CITY OF ALBUQUERQUE

Re: Girard Townhomes, 1921 Girard ,
Request for Permanent C.O. - Approved
Engineer's Stamp dated: 09-15-09 (H-16/D143)
Certification dated: 05-17-10

Re: Girard Townhomes Grading and Drainage Plan
Engineer's Stamp date 9-15-09 (H16/D143)

Re: Certification Submittal for a Temporary Building Certificate of Occupancy
(C.O.) for Girard Town Homes, [H-16 / D 143]
1921 Girard NE
Engineer's Stamp Dated 05/17/10

ENGINEER'S SEAL	GIRARD TOWNHOMES	DRAWN BY WCUJ
	TRAFFIC CONTROL LAYOUT	DATE 9-10-09
	 Rio Grande Engineering 1806 CENTRAL AVENUE SE ALBUQUERQUE, NM 87106 (505) 872-0899	2009-LAYOUT-0-08-09
DAVID SOULE P.E. #14522		SHEET #
		JOB # 2929

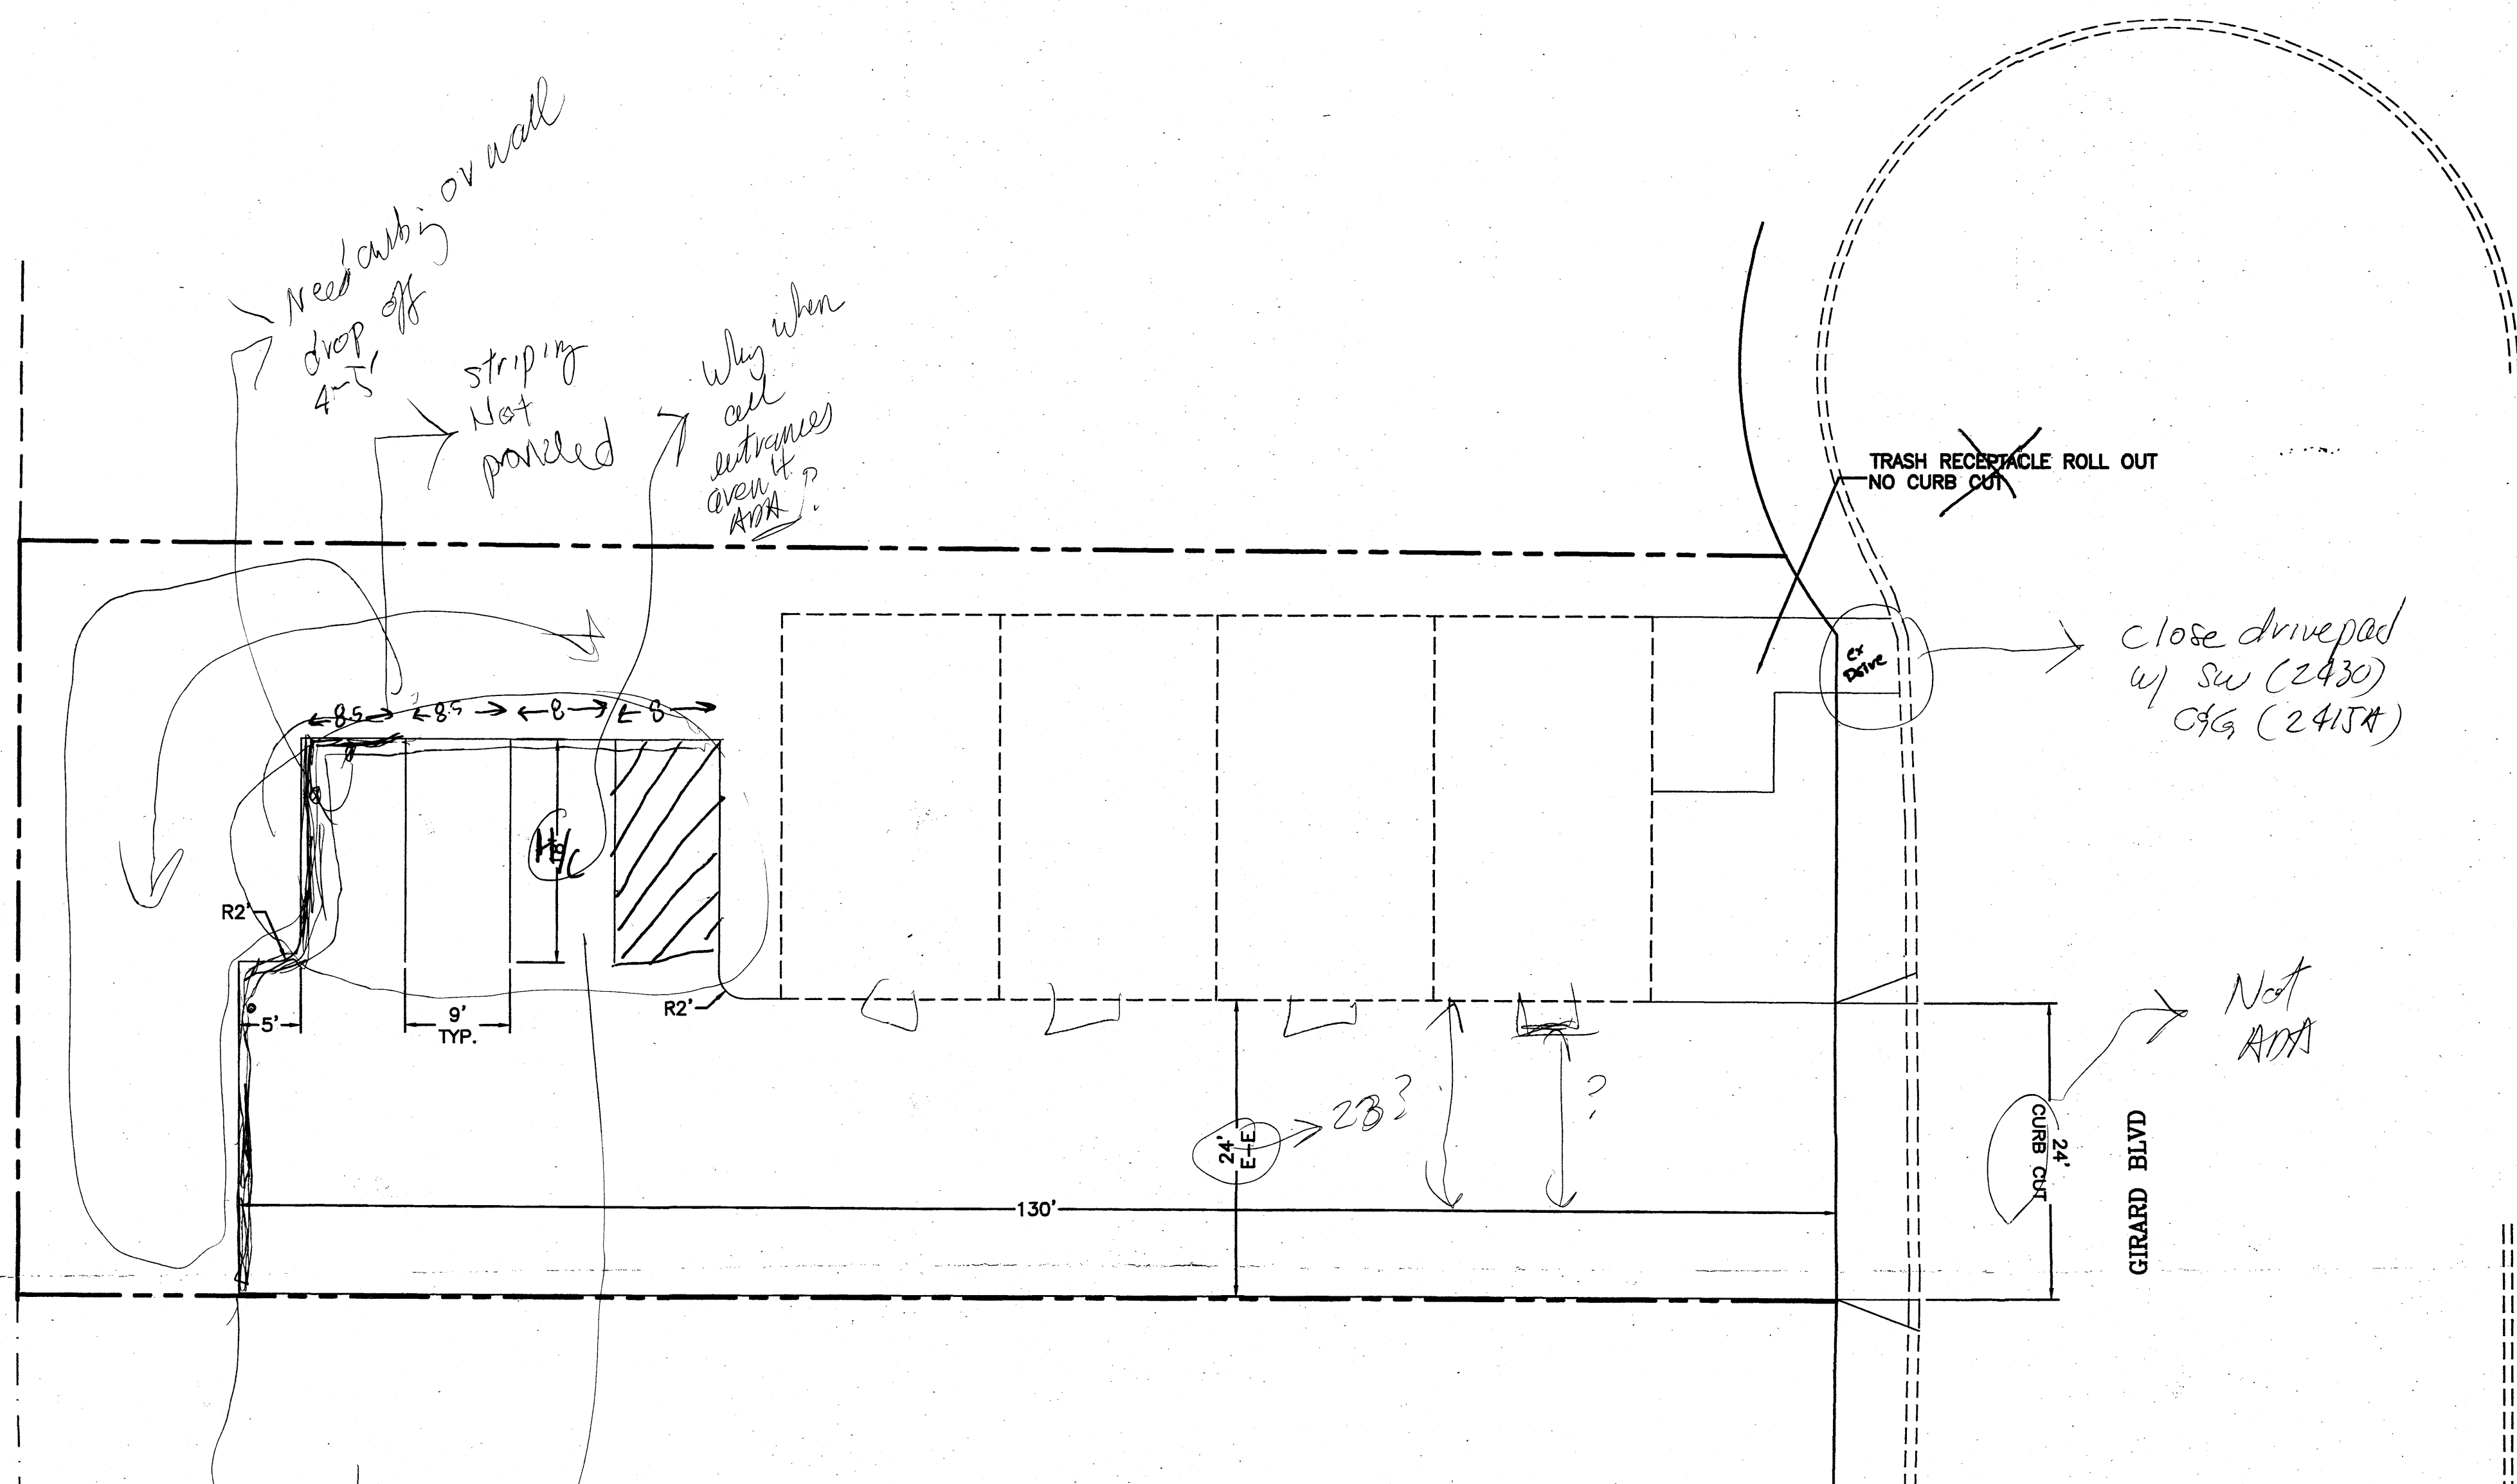
The following items will need to be addressed prior to issuance of a Permanent Certificate of Occupancy: pavement markings/stripping for proposed stalls will need to be provided (ADA will need signage and pathway striping); curbing (slotted for drainage) will be needed to provided around the perimeter of the driving aisle and stall fronting the proposed pond; does the drivepad fronting Girard need to be closed (with sidewalk and curb and gutter)?; your drive aisle doesn't show planter in front of entrance (need to show on site plan, will this reduce the over drive aisle width?). Once these issues have been addressed you'll need to re-submit the total package for Permanent C.O.

ENGINEER'S SEAL  DAVID SOULE P.E. #14522	GIRARD TOWNHOMES	DRAWN BY WCVJ
	TRAFFIC CONTROL LAYOUT	DATE 9-10-09
	 Rio Grande Engineering 1806 CENTRAL AVENUE SE SUITE 201 ALBUQUERQUE, NM 87108 (505) 872-0888	SHEET # 2829

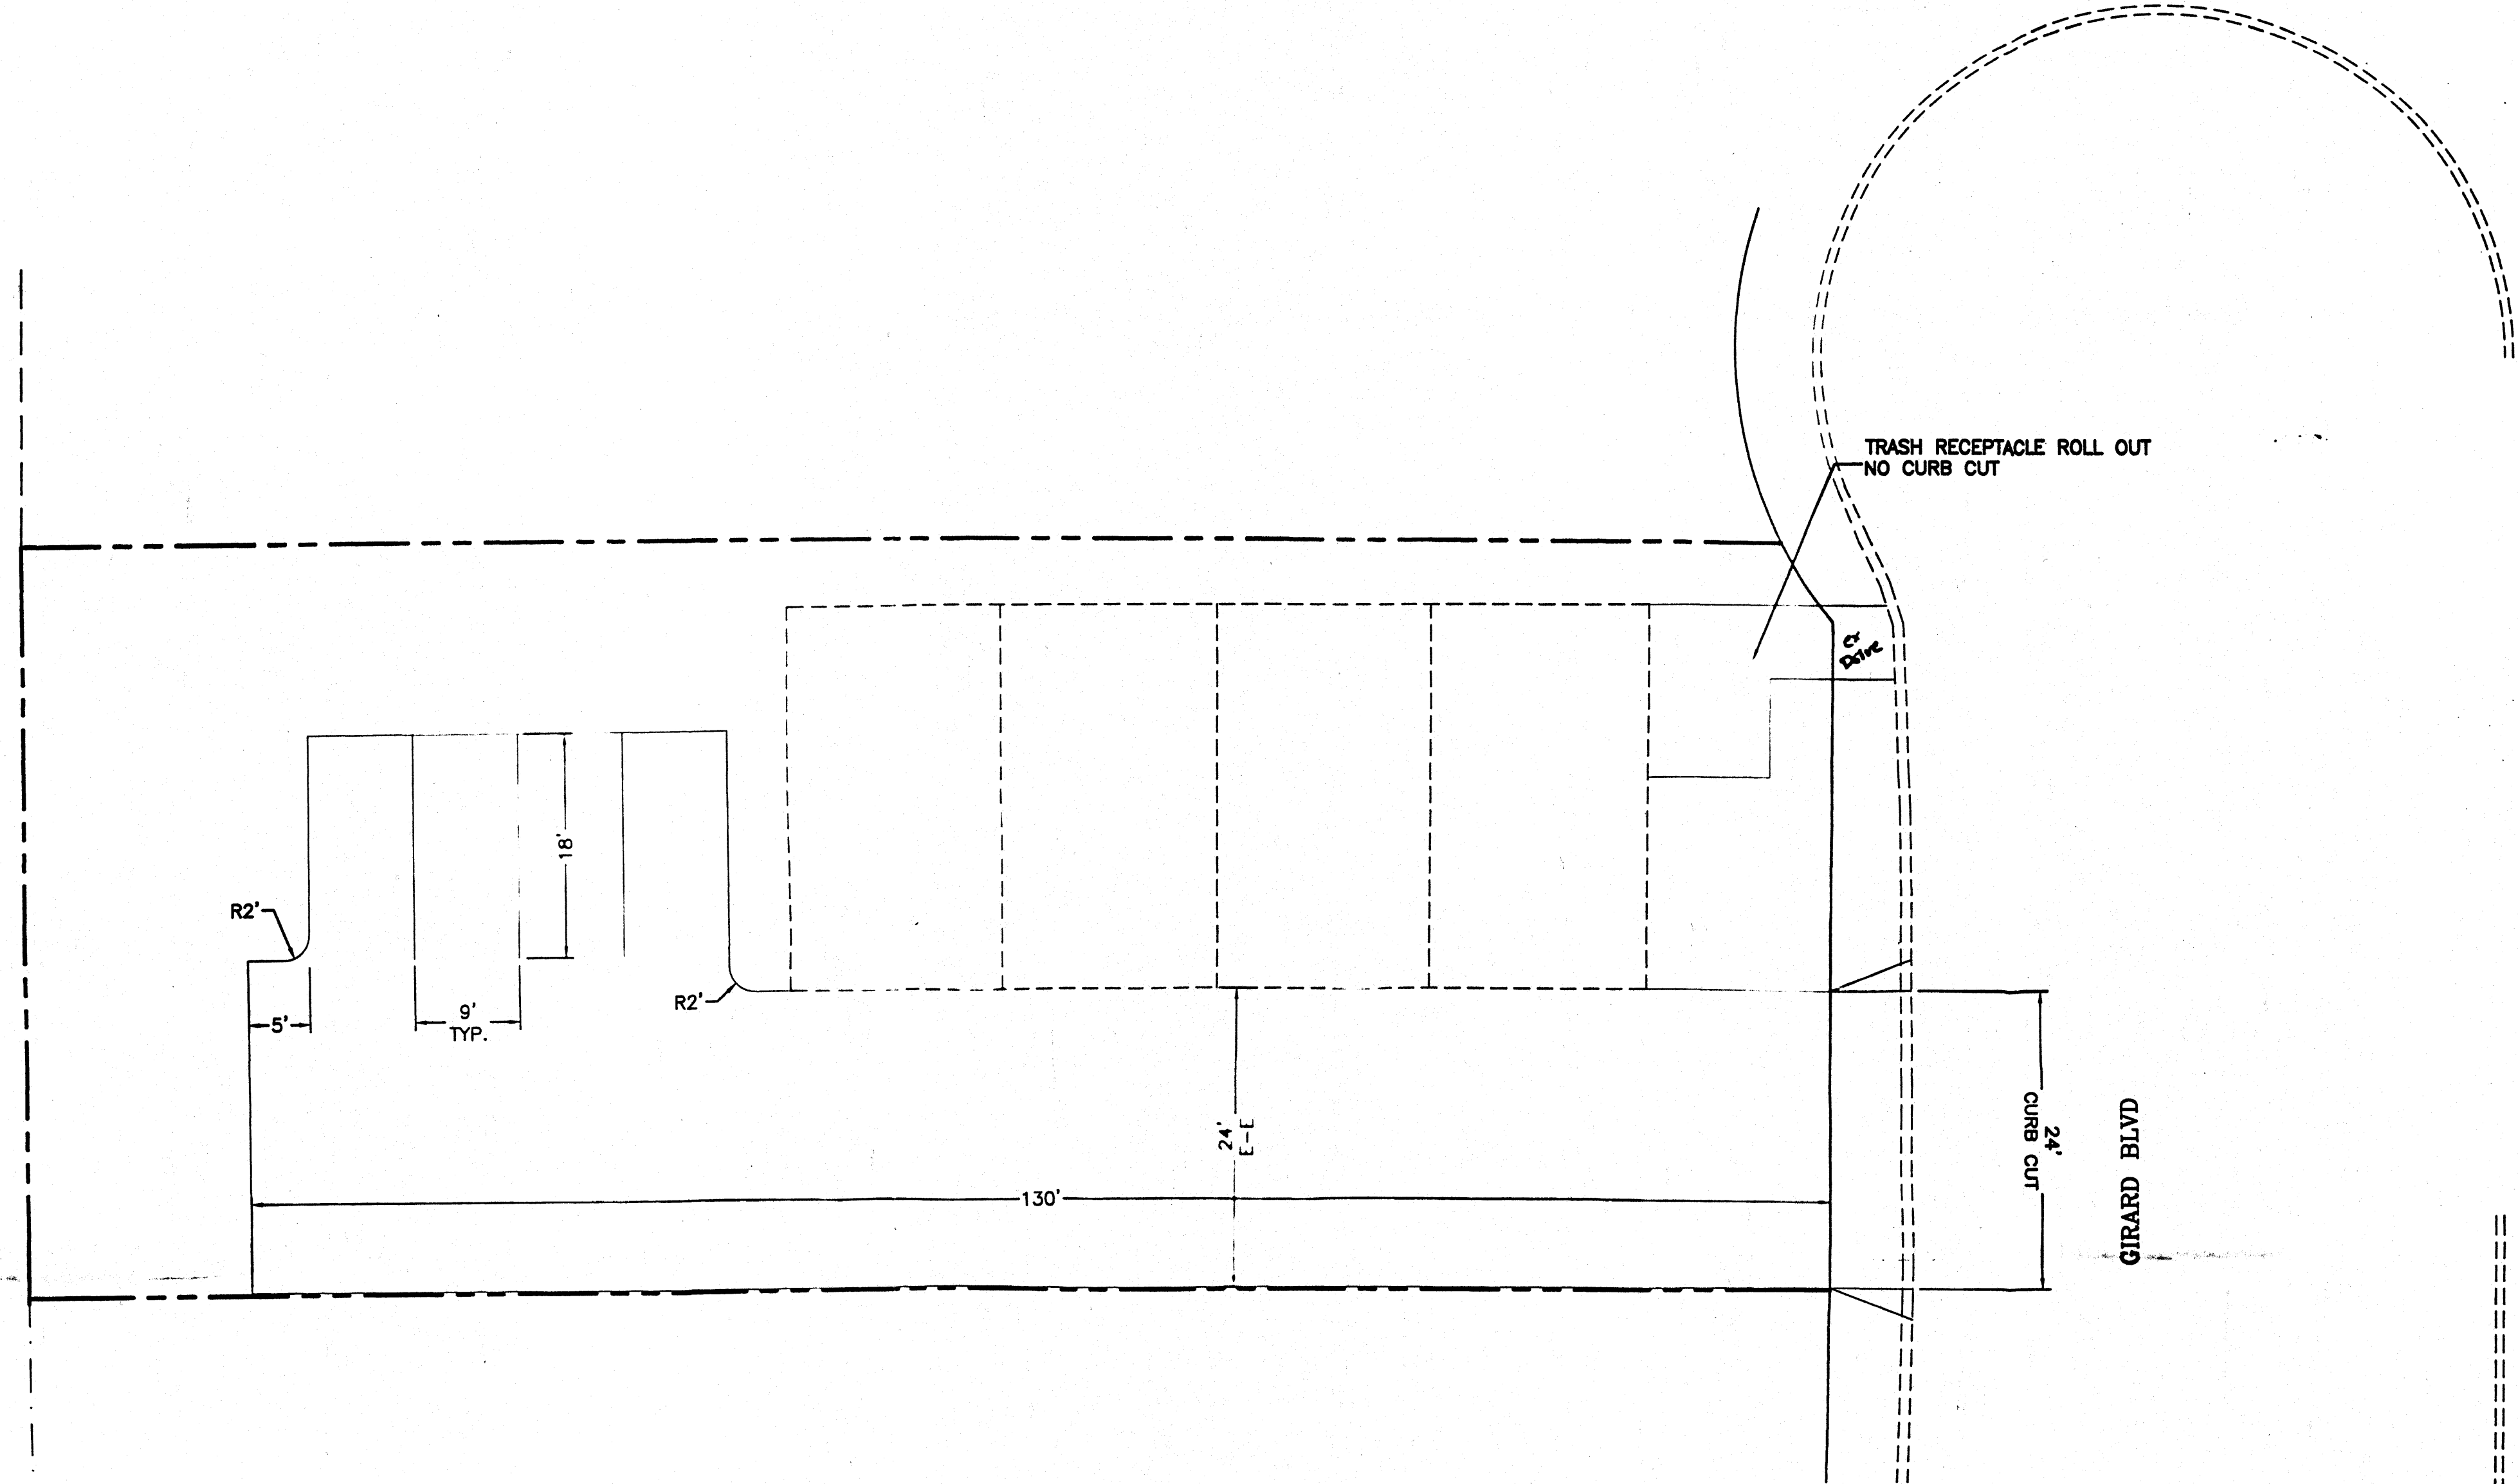
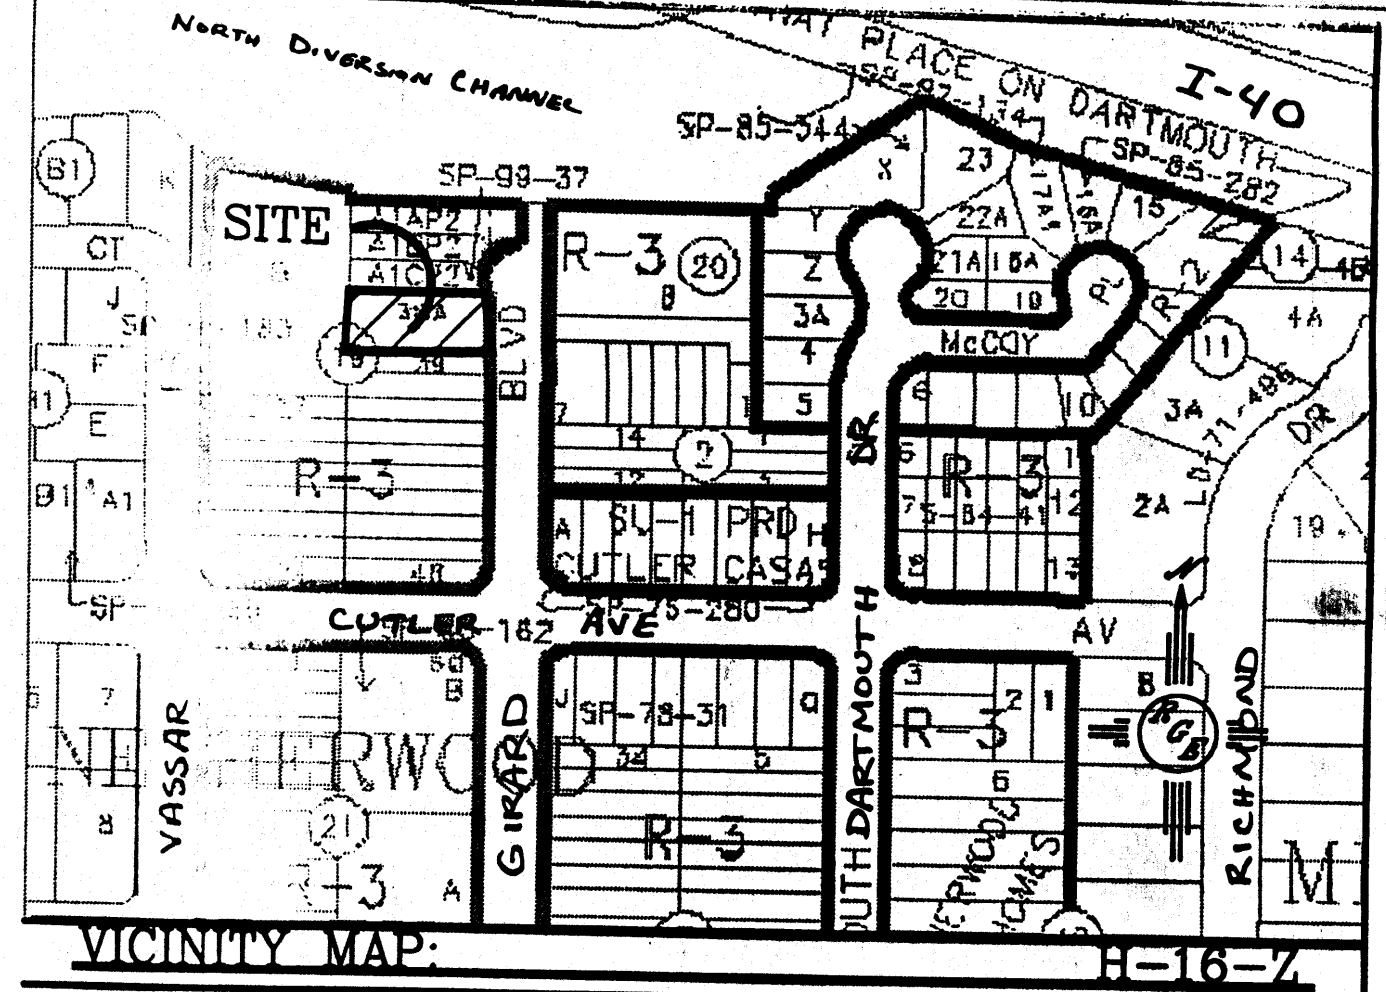
09/25/09
Zoning only requires 3
spaces, so one space
will be removed. OK to
show on as-built w/
no resubmittal
